**Subject:** Eagle Rising SF2225 Plat Filing 1 Response Letter and EDARP Upload

Our responses to the EPC November 2024 Plat and related documents review comments have been uploaded EDARP.

EDARP Review Comments														
Eagle Rising Final Plat Filing No. 1 (Minor) SF2225														
Comment Number ID	Document Submitted	Agency	Attachments	Reviewer Name	Reviewer Date	Redline Document	Page	Reviewer Comment	Applicants Disposition	Applicant Response Date	Document	Page	Applicant Comment/Response	EI Paso County Response to Applicant 10/18/24 Comments
1	Final Plat Eagle Rising Filing No 1	PCD Engineering Division	Yes	Edward Schoenherr	11/6/2024 12:09	(Plat redlines)	1	Unresolved. Circled Note 16 "Driveways currently exist for 10195 Kurie Drive and 7495 Eagle Wing Drive. Individual Lot Owners are responsible for any necessary driveway culver construction and driveway grading	E - Answer provided	12/2/2024	Final Plat Eagle Rising Filing No 1	-	No response to applicant's previous response: "10195 Kurie Road driveway in existence since before 1960 prior to requirement for driveway permits. Evidenced by caboose and building permits for existing detached garage (1997) and existing house (

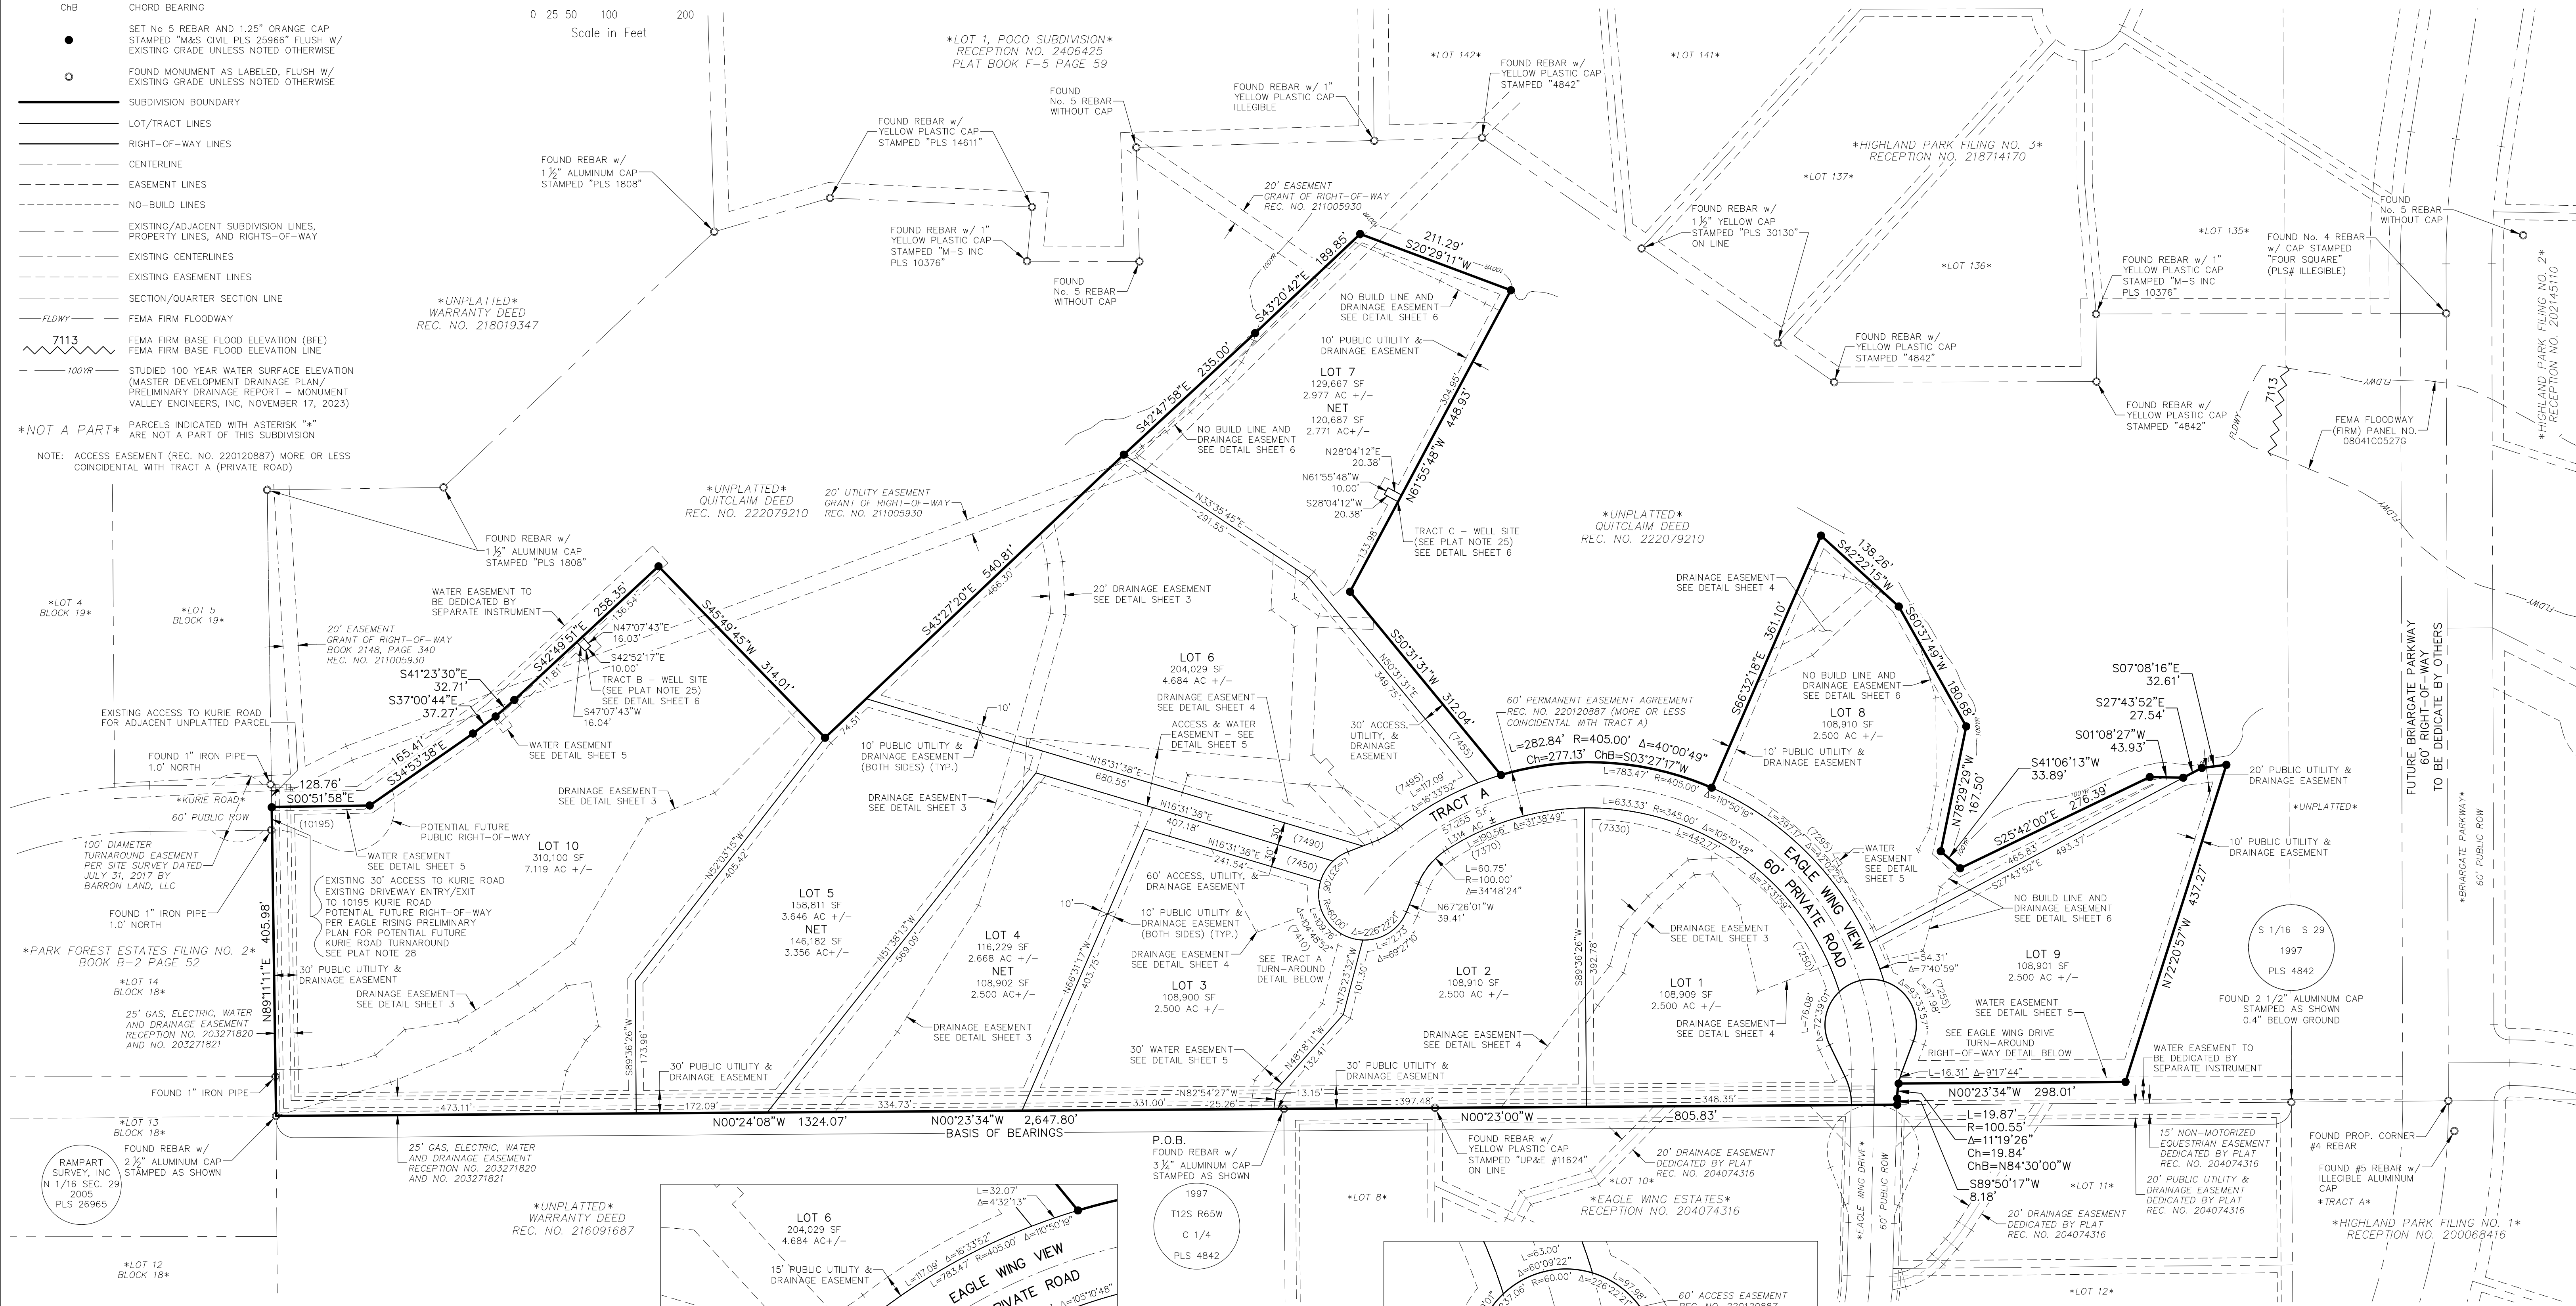
3	Final Plat Eagle Rising Filing No 1	PCD Engineering Division	Yes	Edward Schoenherr	11/6/2024 12:09	(Plat redlines)	1	Unresolved. Circled Note 28 "When four or more lots access Kurie Road, a turnaround is required to be constructed as shown on the Preliminary Plan"	E - Answer provided	12/2/2024	Final Plat Eagle Rising Filing No 1	1,2,3	Per BOCC Resolution No. 24-442, see updated Note 28 and dotted line on plat for potential ROW.	
4	Final Plat Eagle Rising Filing No 1	PCD Engineering Division	Yes	Edward Schoenherr	11/6/2024 12:09	(Plat redlines)	2	Unresolved. Circled Kurie Road ROW	E - Answer provided	12/2/2024	Final Plat Eagle Rising Filing No 1	1,2,3	Per BOCC Resolution No. 24-442, see updated Note 28 and dotted line on plat for potential ROW.	
5	Final Plat Eagle Rising Filing No 1	PCD Project Manager	Yes	Ryan Howser	11/6/2024 12:09	(Plat redlines)	2	Unresolved repeat comments from prior reviews. This note is not adequate per LDC Sec. 8.4.4.B which states that either public ROW is dedicated, or land for public ROW is preserved. You must depict the land for dedication for future ROW, per the discussion staff had with the applicant. Staff is now recommending a condition of approval to be added to the preliminary plan with the most recent extension request which would require land dedication at this stage.	E - Answer provided	12/2/2024	Final Plat Eagle Rising Filing No 1	1,2,3	Per BOCC Resolution No. 24-442, see updated Note 28 and dotted line on plat for potential ROW.
